May 9, 2023

**RE: The Springs of Ballentine – Fire Sprinkler  
Fuquay-Varina, NC – Harnett County**

Plans relative to the above-named project received on April 27<sup>th</sup>, 2023 have been reviewed for general compliance with the 2018 North Carolina Building Code and the National Fire Protection Association (NFPA 13) Standard for the Installation of Sprinkler Systems, 2013 edition. Per Chapter 23 of this standard, the following shall be submitted with working plans to perform a complete review.

Date:
02/13/2022

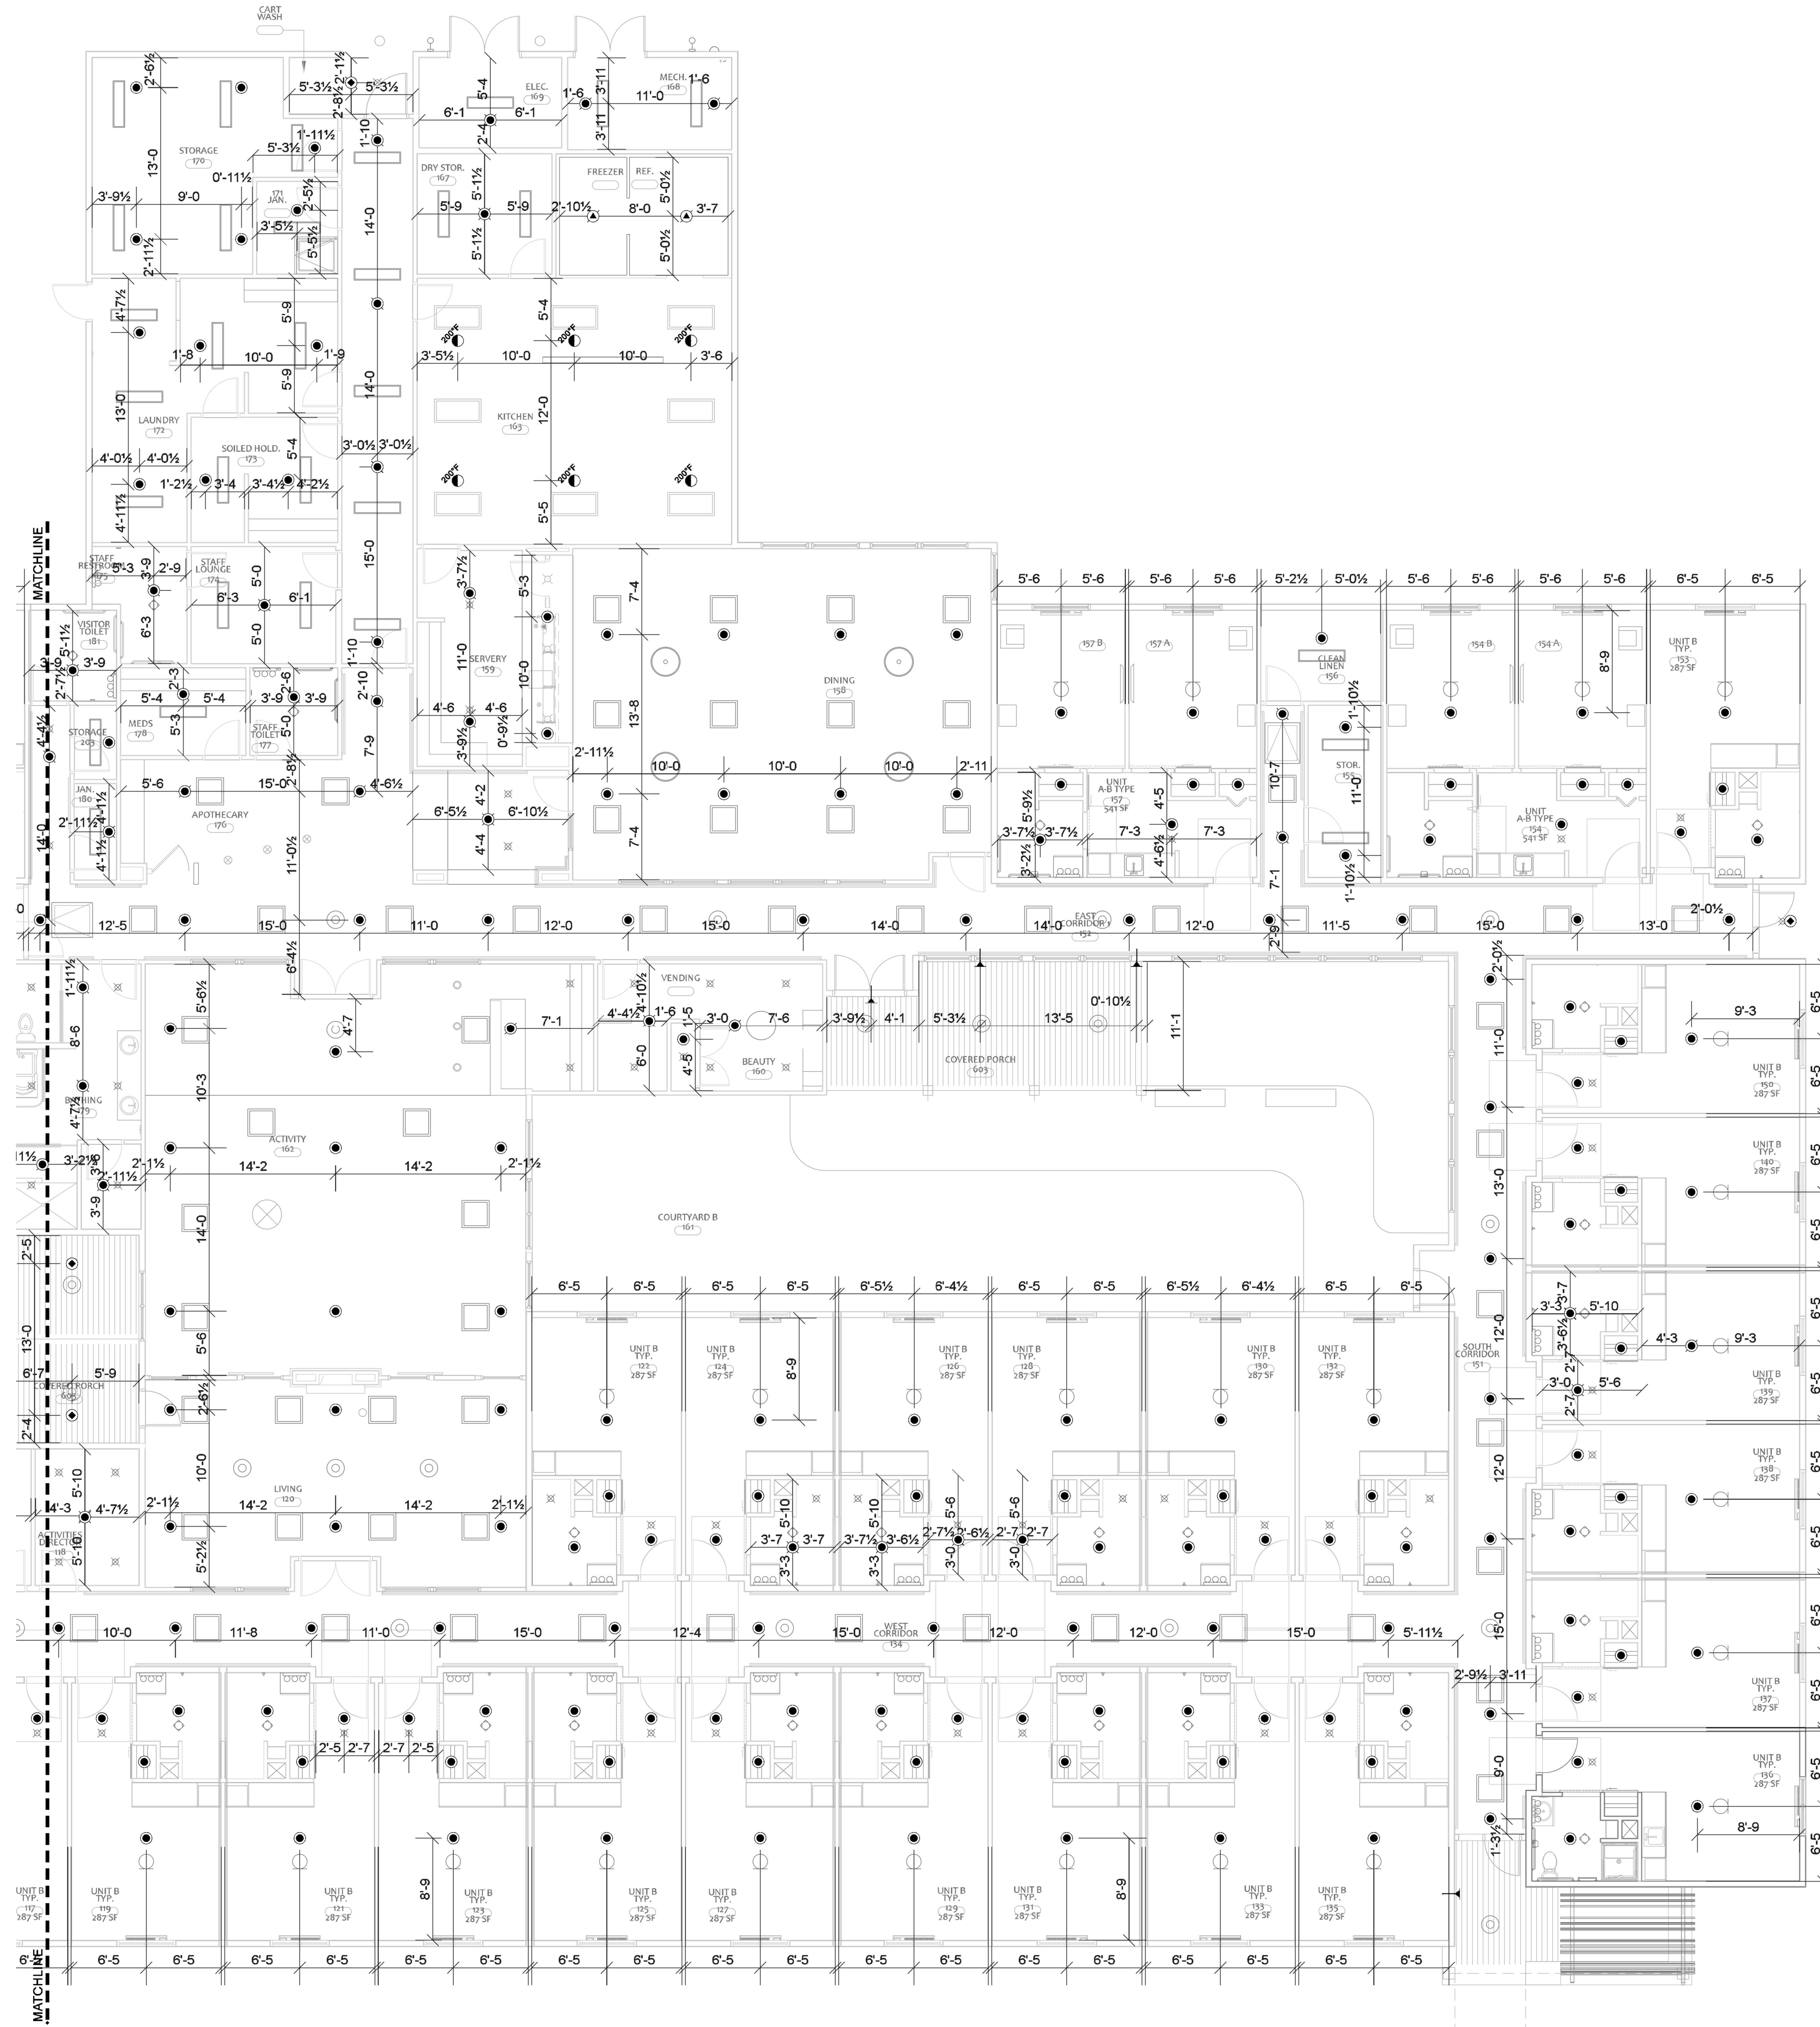
3. Are there any small enclosures in which no sprinklers are to be installed (near Apothecary 176 & Servery 159?) per NFPA 13, Chapter 23, section 23.1.3 #9.

5. Provide total area protected by each system on each floor per NFPA 13, Chapter 23, section 23.1.3 #14.
6. The head count for the Victaulic V3506 appears to not match the plans (too low). Please confirm. This may also impact Viking head VK3021.

7. The sprinkler head outside rear entry near Electric Room 169 appears to not be the correct symbol for the intended head.

8. The symbol for the heads provided in Activity 162 and Lobby 110 are not listed in the Sprinkler head legend.
9. Provide cut sheets for inspectors' test connections per NFPA 13, Chapter 23, section 23.1.3 #23.

10. Show location of the inspectors' test valve on the plan view.
11. Provide cut sheets and location for alarm bells per NFPA 13, Chapter 23, section 23.1.3 #26.
